Planning Services Sign Permit Review Form

Date of Submittal	Application Number	Applicant	Landowner
01/09/2023	SIGN2301-0002	New Home Inc.	Duncans Creek Development Group LLC

Contact Person	Rich Sherman	Contact Number	919-422-2838
Sign Location	17 Duncan Creek Rd.	PIN Number	0630-25-5860.000

SIGN DETAILS

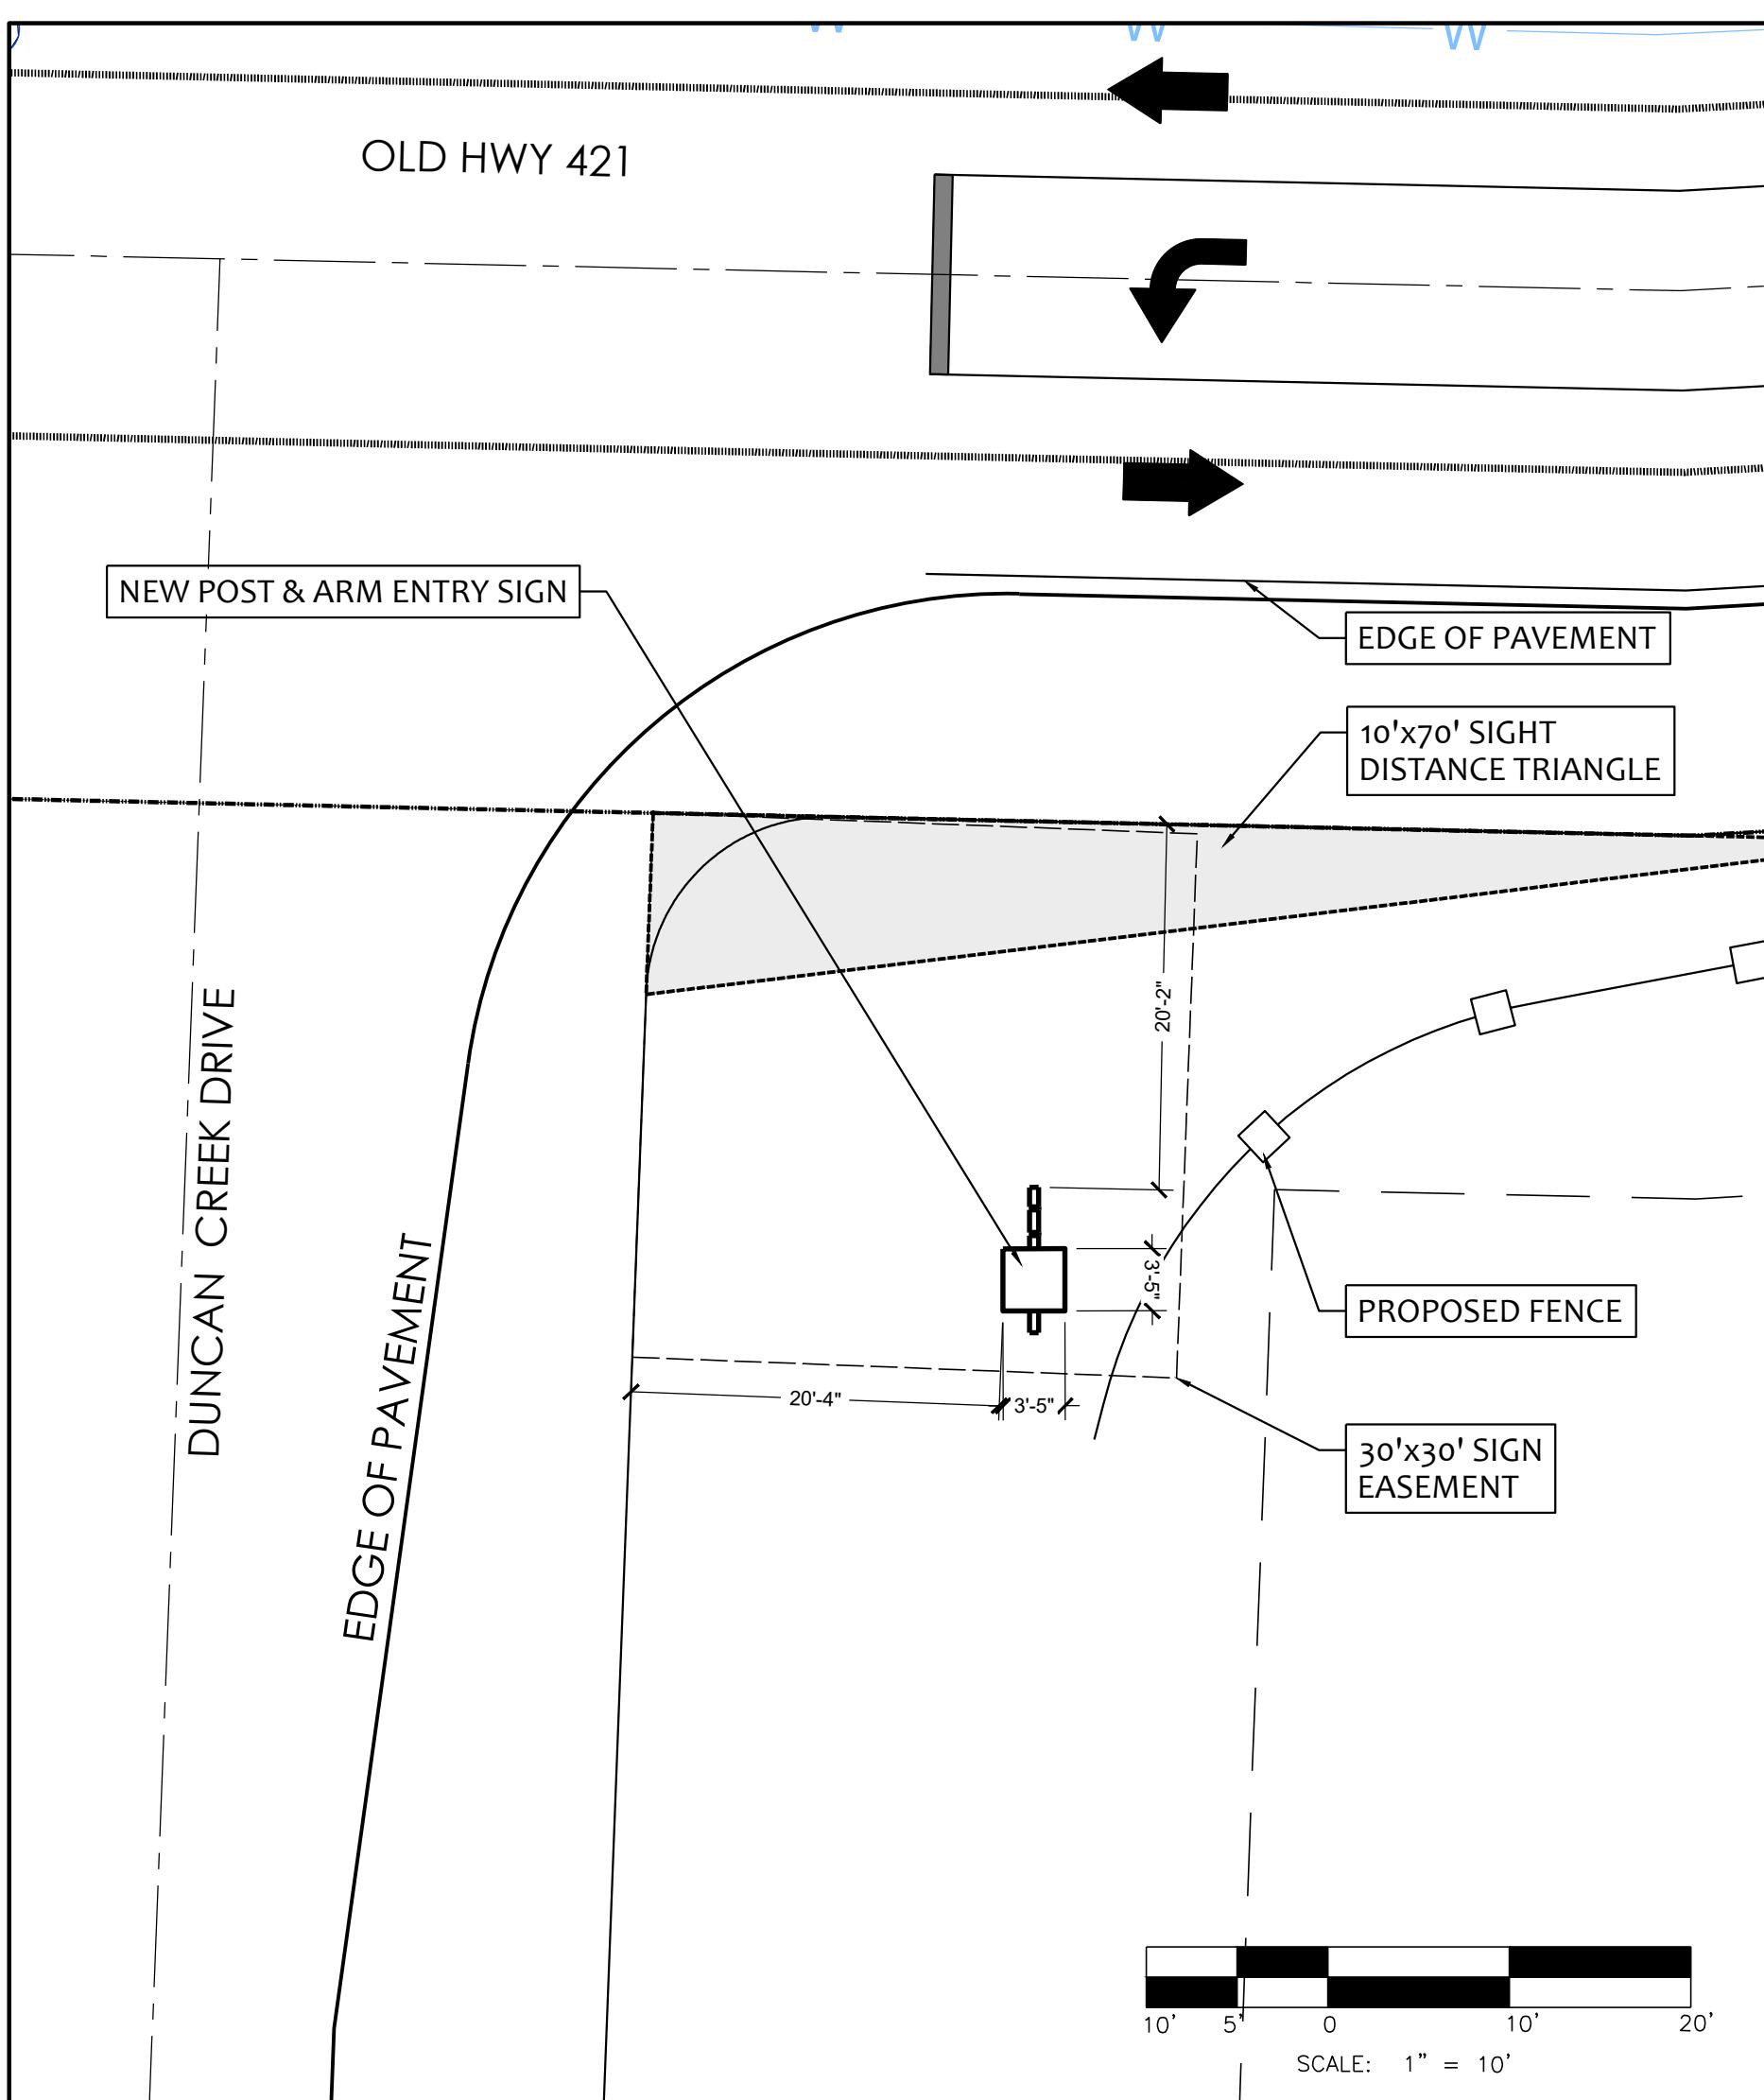
Comments	1. Please reduce the overall height of the sign to 6' or less. 2. Please reduce the overall size of the sign to 50 square feet or less. Overall size of sign is measured to include the entire sign.
-----------------	---
